Our ref: OUT26/951

Subject: Mixed-use residential and commercial development – 135 Badgerys Ck Rd Bradfield (SSD-77458970) – Environmental Impact Statement

Detailed advice to DPHI Planning & Assessment regarding the Mixed-use residential and commercial – 135 Badgerys Ck Rd, Bradfield (SSD-77458970) – EIS

Figure 7: Validated watercourses

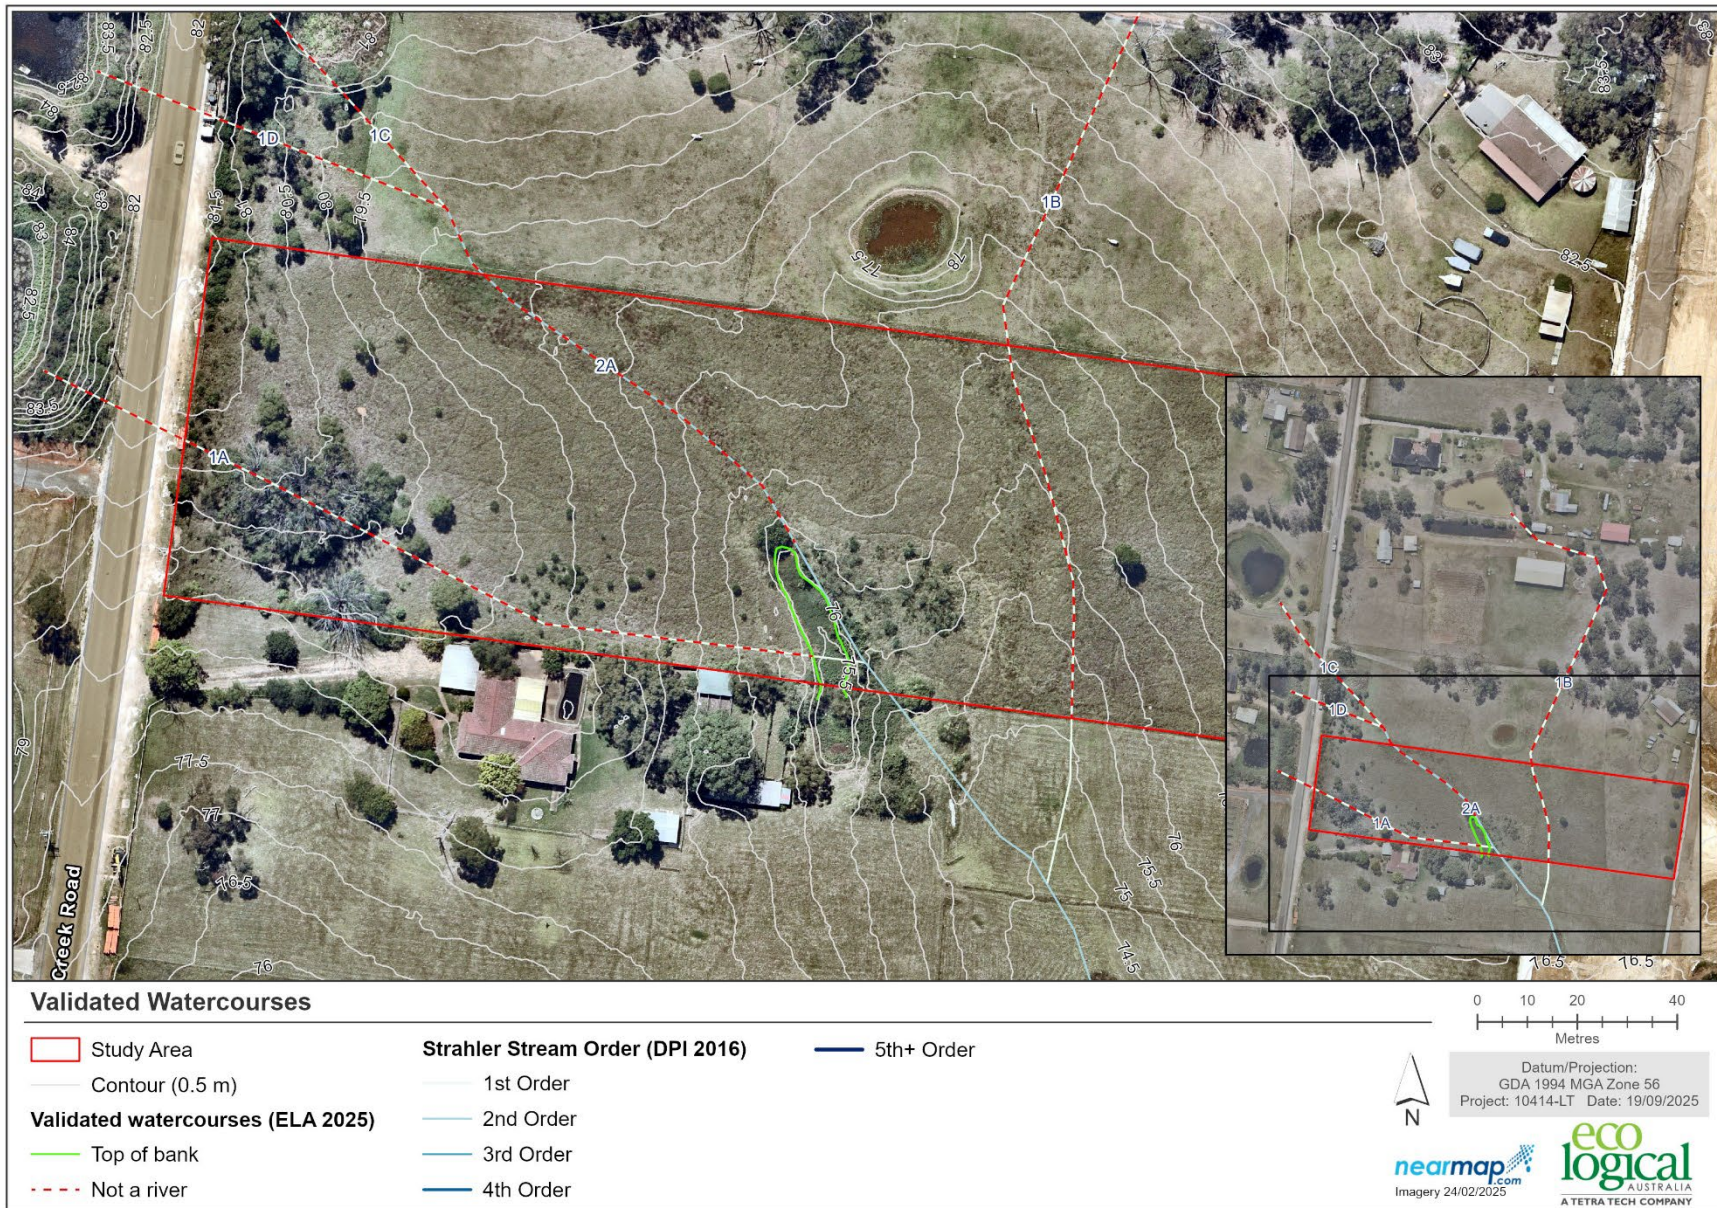
That DPHI requests the proponent to clarify how water entering the site from first order watercourses will be managed once those watercourses on site are removed.

Insufficient information has been provided to confirm how flows from the first order watercourses is to be conveyed through the site and if the Development Control Plan has been considered. The project will cover two first order streams that extend into adjacent lots and it is unclear how flows sourced from these watercourses will be managed.

Figure 13: Recommended riparian corridor and averaging rule to meet the DCCEEW riparian guidelines

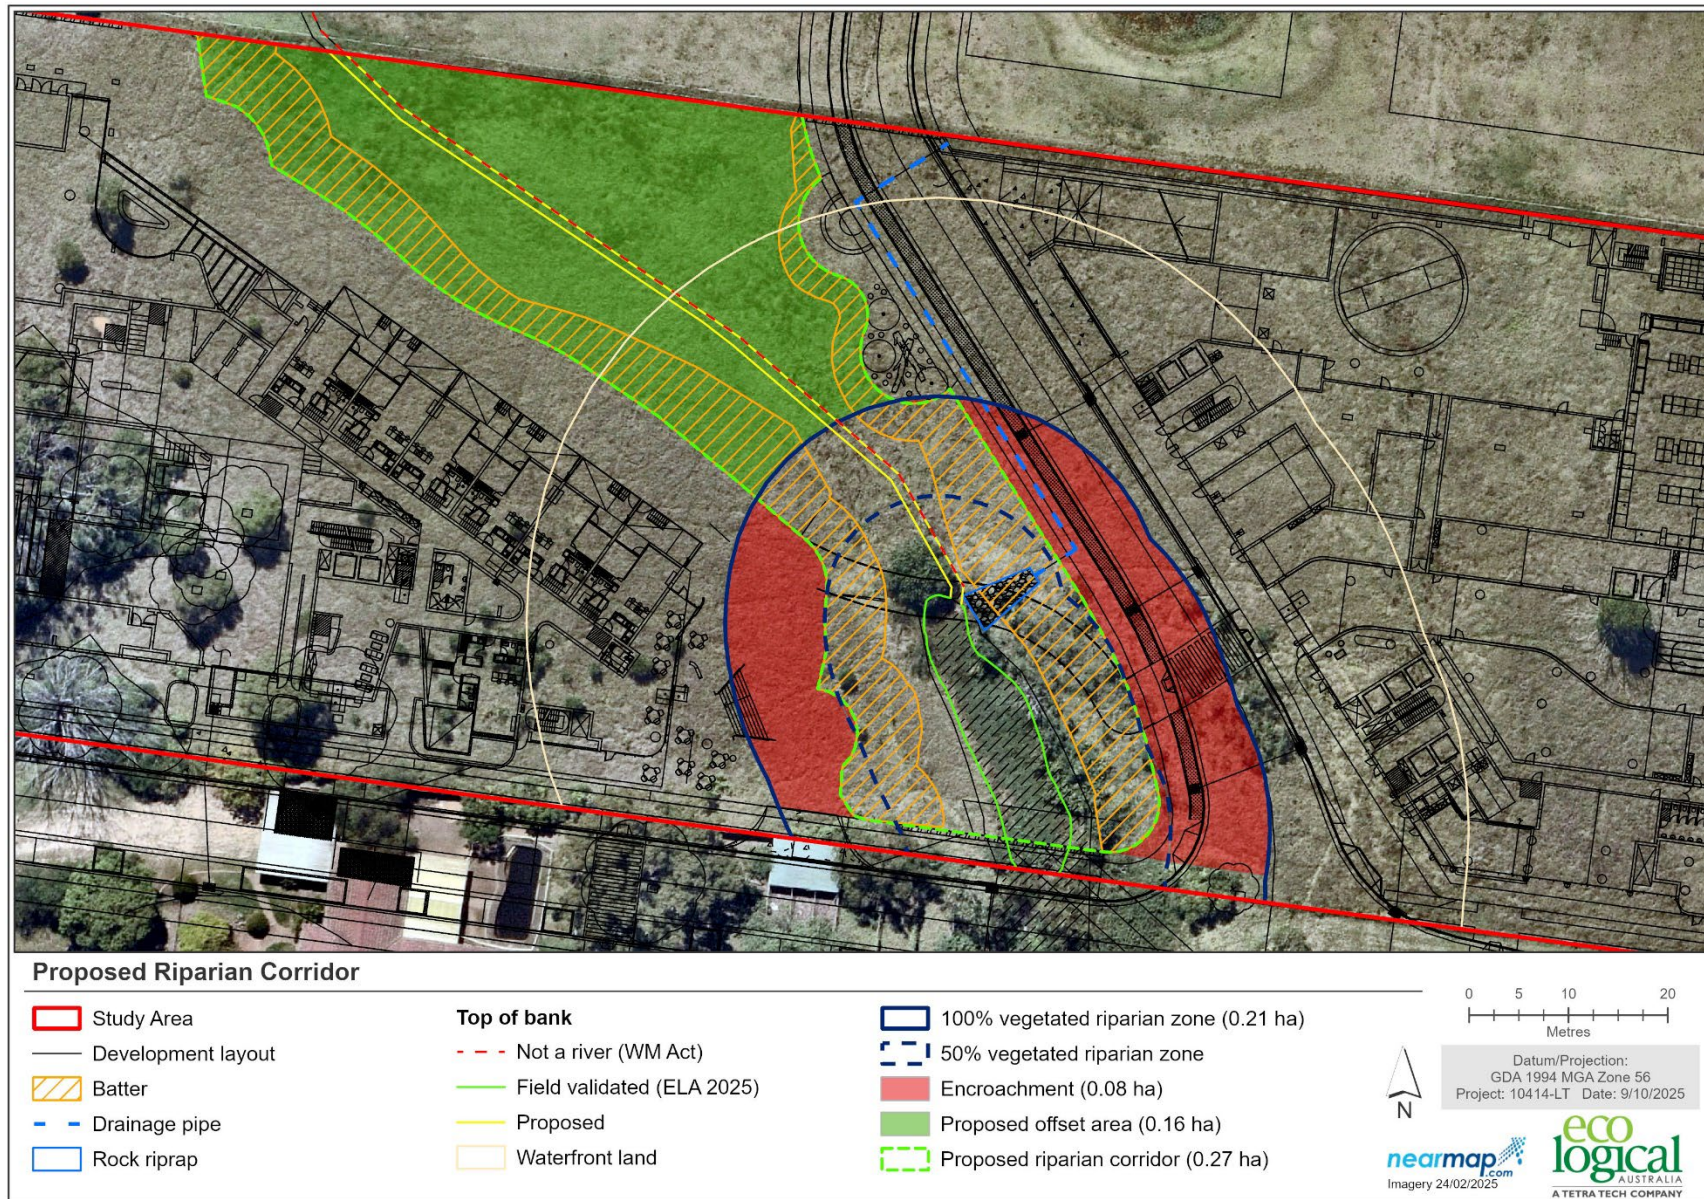
That DPHI requests the proponent to confirm the proposed infrastructure layout meets the buffer requirements from watercourses as defined in the Guidelines for Controlled Activities on Waterfront Land (DCCEEW 2025) and Development Control Plan (DCP) requirements.

Insufficient information has been provided to confirm how the infrastructure layout has addressed the DCCEEW 2025 guidelines. It is recommended the second order watercourse include a naturalised stream design and riparian zone with no encroachments on the inner vegetated riparian zone. It is also noted the DCP outlines that all second order watercourses should be rehabilitated to a natural state.
